Re : Planning Application P/53/19/L for Listed Building Consent for the Inglenook Hotel. Deadline for objections 1st August.

I would like to object to the above Listed Building Consent for the demolition of a chair store and realignment of curtilage listed wall. The reason given for the demolition and realignment is to enable a safe access to a proposed development to the rear of the Inglenook.

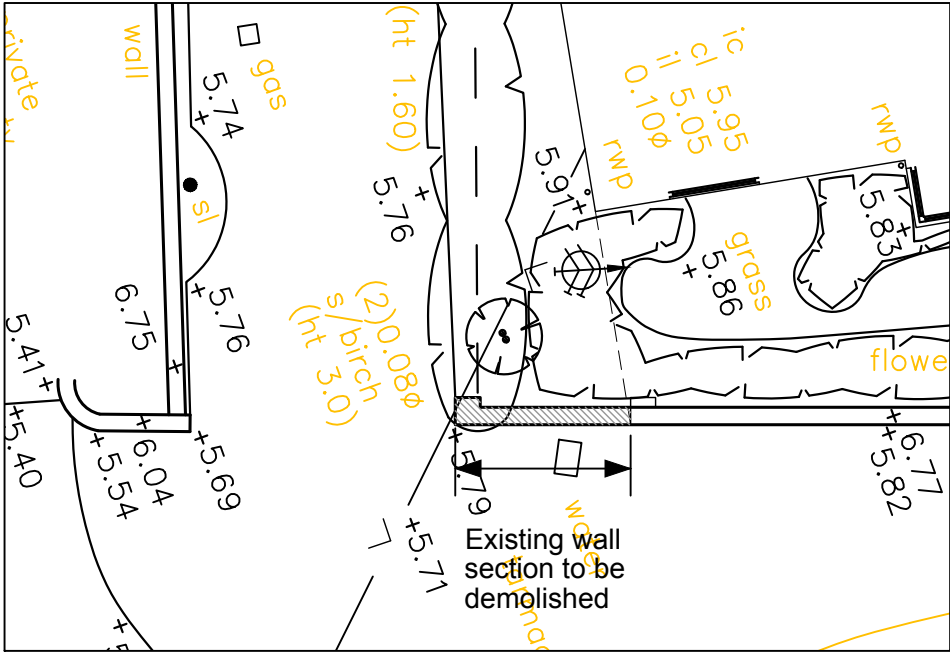
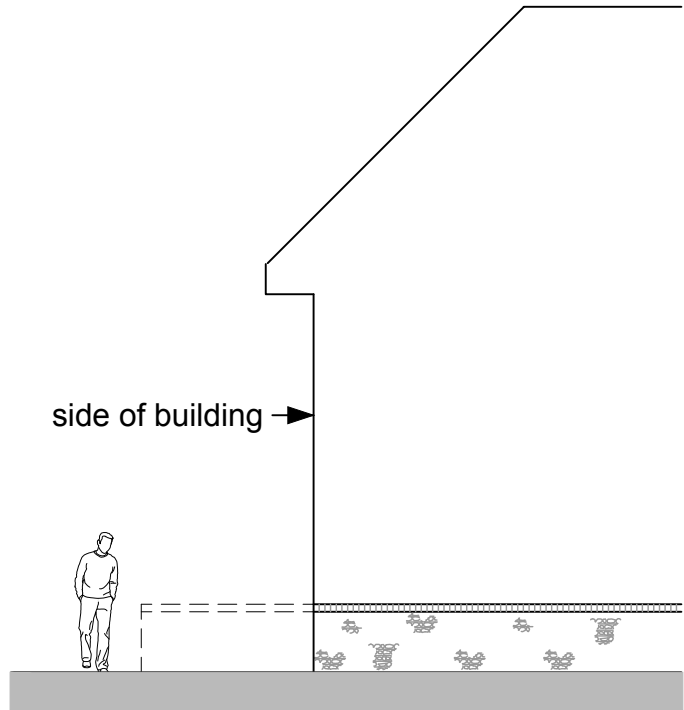
The limited widening of the access road will significantly increase vehicle movements entering and exiting the site onto the Pagham Road and will have an adverse effect on highway safety and convenience of road users. (The Block Plan 31 does not show the benefit of realignment of the wall or removal of the store with regard to the overall width of access being achieved). This information has been supplied in the proposed planning application which states it will be increased from 3.5m to 5.3m after alignment. An example of vehicle widths: A BMW X5 is 2.4m wide, average car 2m, refuse/commercial vehicle 3m wide. In addition it is proposed that pedestrians will be using a shared surface in the access lane.

Manual for Streets item 6.3.22 states **"that a minimum unobstructed width for pedestrians should generally be 2m"**. Therefore, the width of 5.3m achieved could cause a conflict to arise between traffic and pedestrians.
